Table 1 – Department of Planning and Infrastructure

Table 2 – City of Sydney

**THE RIBBON
SWEPT PATH REVIEW
GROUND FLOOR**

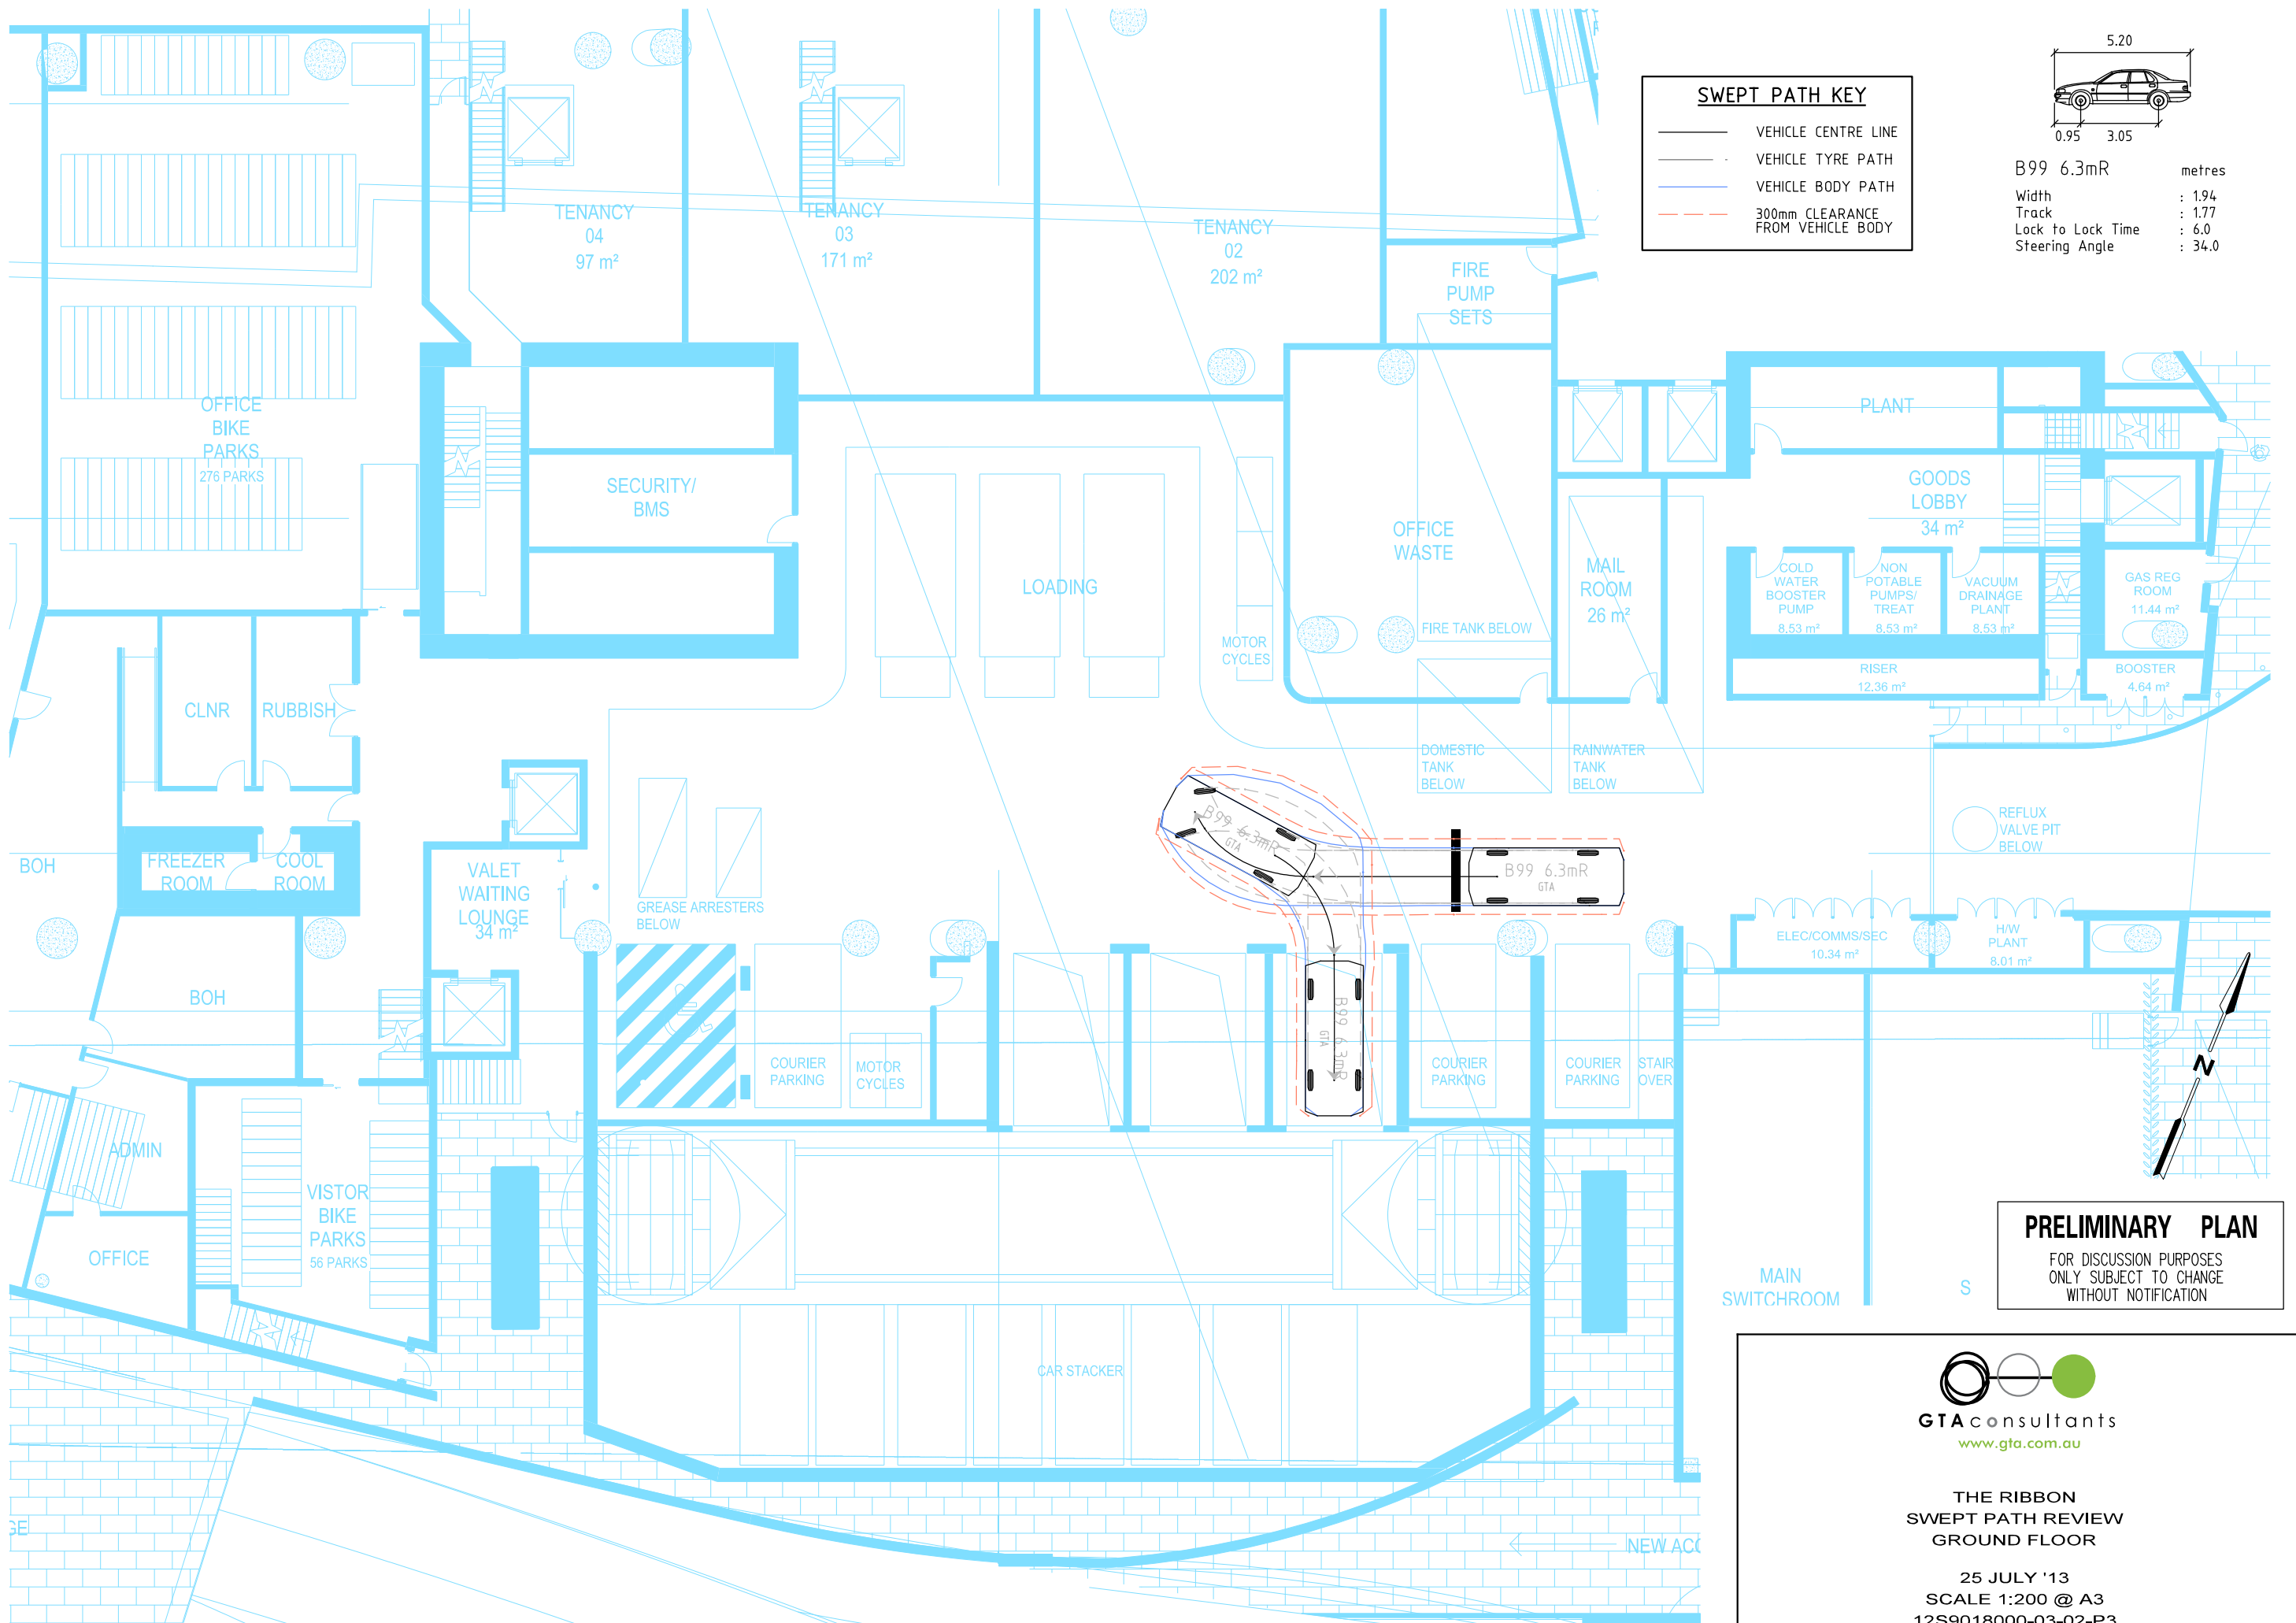
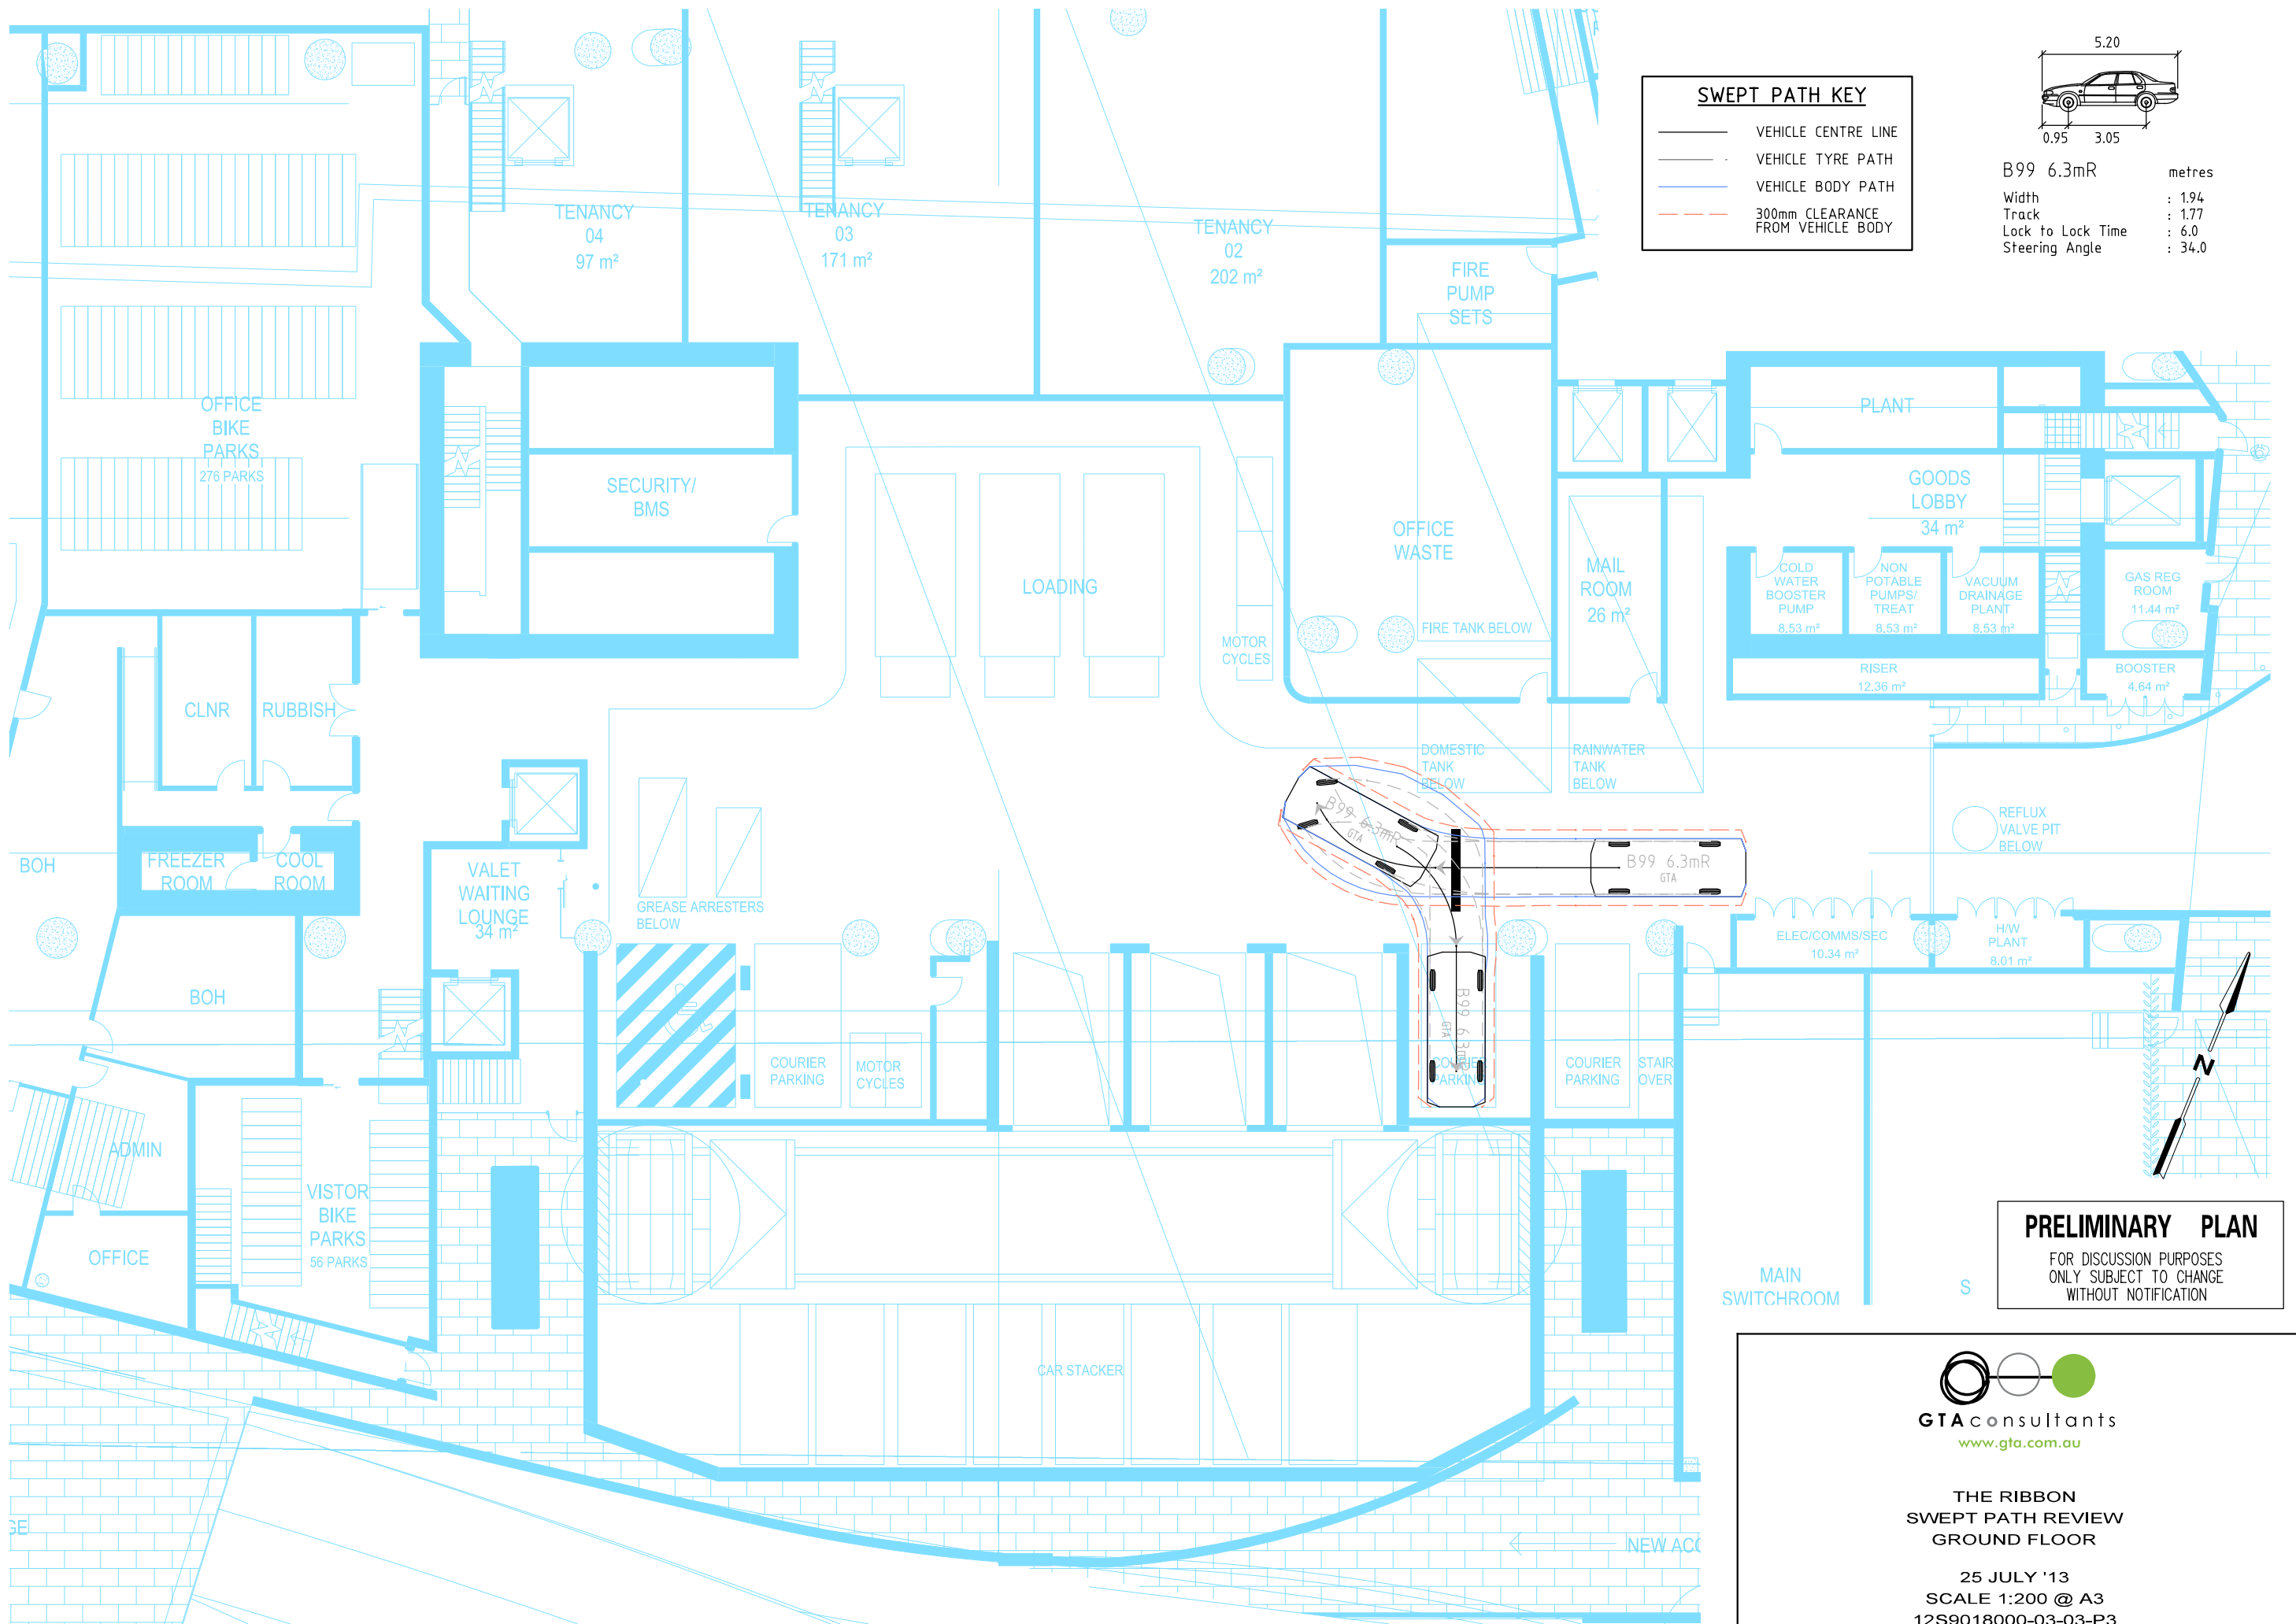
Category	Recommendation/issue	Comment
	A minimum path width of 1.6m is to be maintained within the loading area. In particular, the pinch point on the eastern corner of the hydrant booster (at the entrance to the loading zone) should be rectified.	Within the loading area a shared zone is to be linemarked and be at least 16m wide. A 1.2m zone will be provided at the 'pinch point' of the eastern corner.
	A Green Travel Plan and transport access guide should be prepared prior to the occupation of the building.	A Green Travel Plan was a recommendation of the Transport Impact Assessment originally submitted, and will be prepared prior to the occupation of the building.
Heritage	<p>A complete Heritage Impact Statement should be prepared for the proposal. This should consider a larger catchment of heritage assets, including those in the western CBD, Pyrmont peninsula, and Darling Harbour.</p> <p>The Heritage Impact Statement should discuss resultant loss of heritage character and setting for heritage items and special character areas within the City of Sydney as a result of the visual impacts of the proposal.</p> <p>Section drawings should be provided to demonstrate the impact of the proposal on Sewage Pumping Station No. 12 and other heritage assets.</p> <p>The Heritage Impact Statement should assess the impacts on important views from Sydney Harbour in respect of the Sydney Regional Environmental Plan (Sydney Harbour Catchment) 2005, specifically Section 25 Foreshore and Waterways Scenic Quality that requires certain matters to be taken into consideration in relation to the maintenance, protection and enhancement of the scenic quality of foreshores and waterways.</p> <p>The Heritage Impact Statement should assess how the bulk and scale of the proposal maintains visual connectivity between the western precinct of the CBD and Darling Harbour, the Pyrmont Peninsula, and Pyrmont Bridge.</p> <p>The Heritage Impact Statement should assess the geographic connectivity between heritage items in the harbour and between the CBD and Pyrmont Peninsula.</p> <p>The Heritage Impact Statement should demonstrate how the proposal interprets the natural and cultural heritage of the area</p> <p>Any proposed relocation of the Carousel and Organ should be preceded by a thorough planning exercise developed in accordance with the policies and procedures outlined in the Conservation Management Plan for these items (SHFA 2012).</p>	Refer Section 2.5.2 of Response to Submissions.
